# CITY OF ALBUQUERQUE

May 16, 2018

RE: **Signal Village Subdivision**  
**Drainage Report**  
**Engineer's Stamp Date 5/10/2018**  
**Hydrology File: C20D078**

Drawing file: 2018-05-11 / EXHIBIT A - 5.10.18.pdf

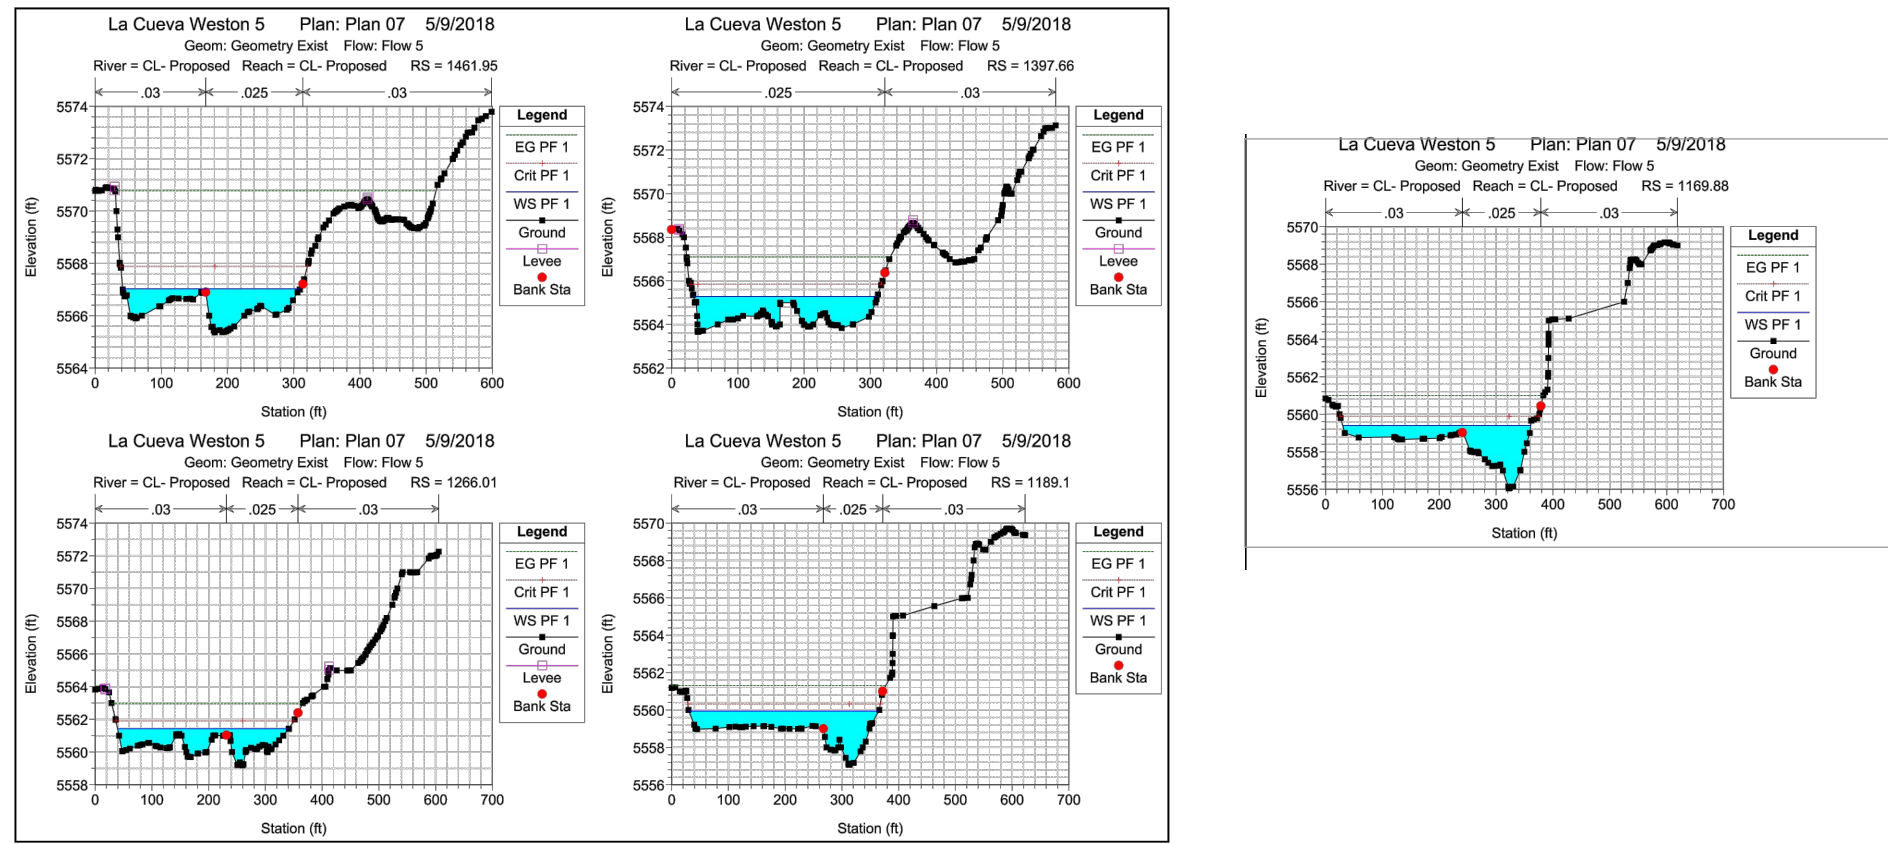
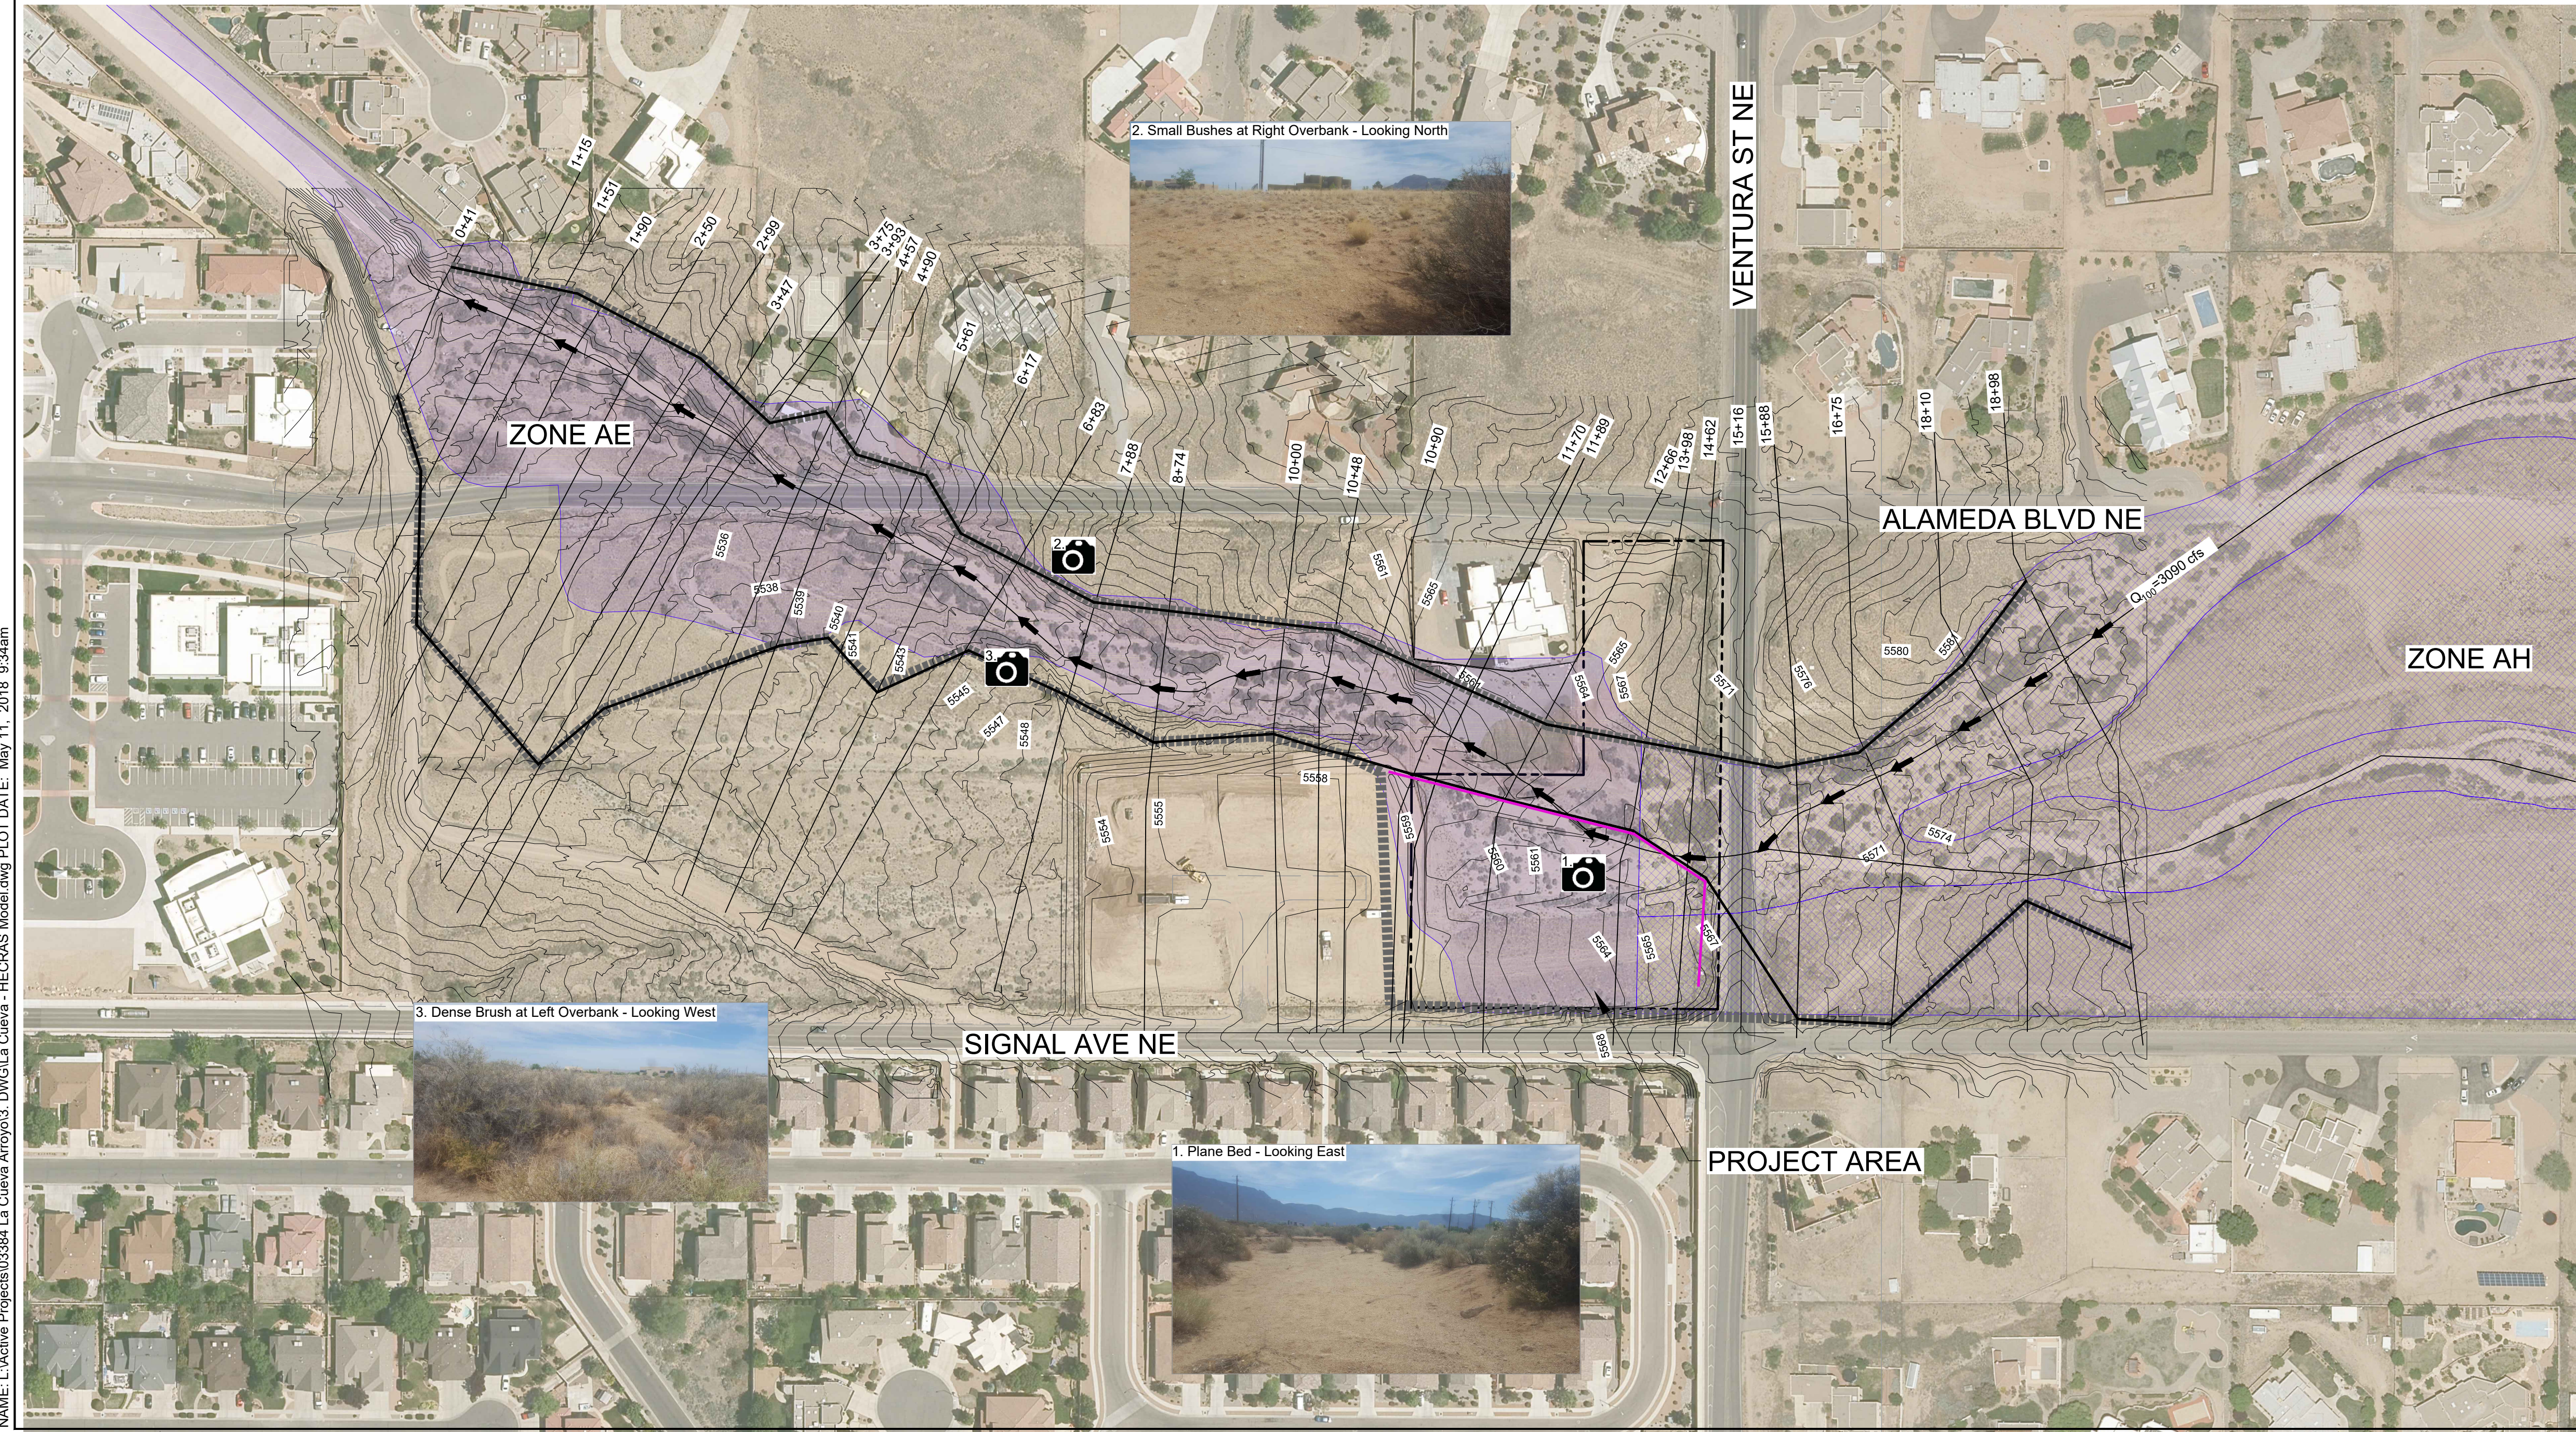
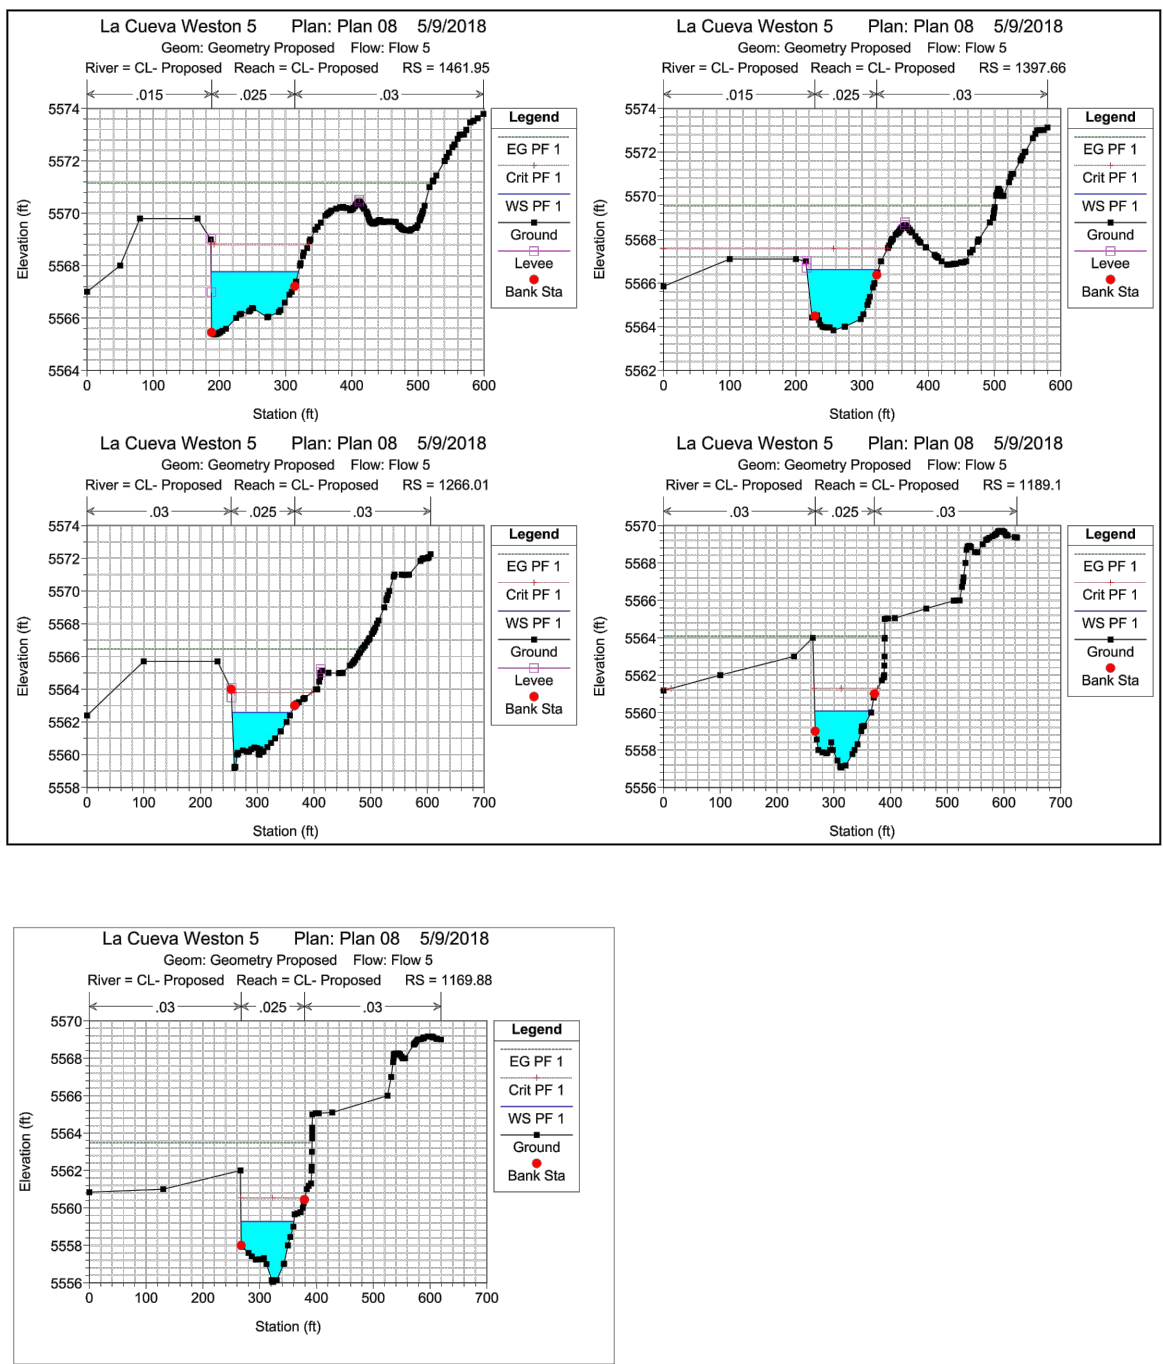
1. Supercritical flows are shown at nearly every cross section in the HEC-RAS model. Irregularities in natural arroyos generally prevent sustained supercritical flow so the model must be changed to subcritical only.
2. The model shows that the proposed fill in the floodplain will cause increased water surface elevations on neighboring properties. This may be allowed if the neighboring properties provide written permission for the specific maximum increase in Base Flood Elevation and Floodplain width associated with this project.

3. It is unclear what condition has been modeled on the lot at 9000 Alameda Blvd. where the owner has placed obstructions in the arroyo and is currently working on a plan to resolve violations of the Flood Hazard and Drainage Control ordinance and Section 404 of the Clean Water Act. The report must specifically address what assumptions that are being used in the model of the Signal Village Subdivision. It is possible that cooperation between the two projects may yield a mutually beneficial solution, but that solution must address both the floodplain and the 404 issues. A joint project will have to include restoration of an unobstructed sand bottom channel that preserves sediment continuity through the project area. A joint project will also have to include Agreement and Covenants and a Public Drainage Easements for the floodplain and the scour protection on all developed lots. Permission for increased BFEs will be required from all affected properties including any not being developed at this time.
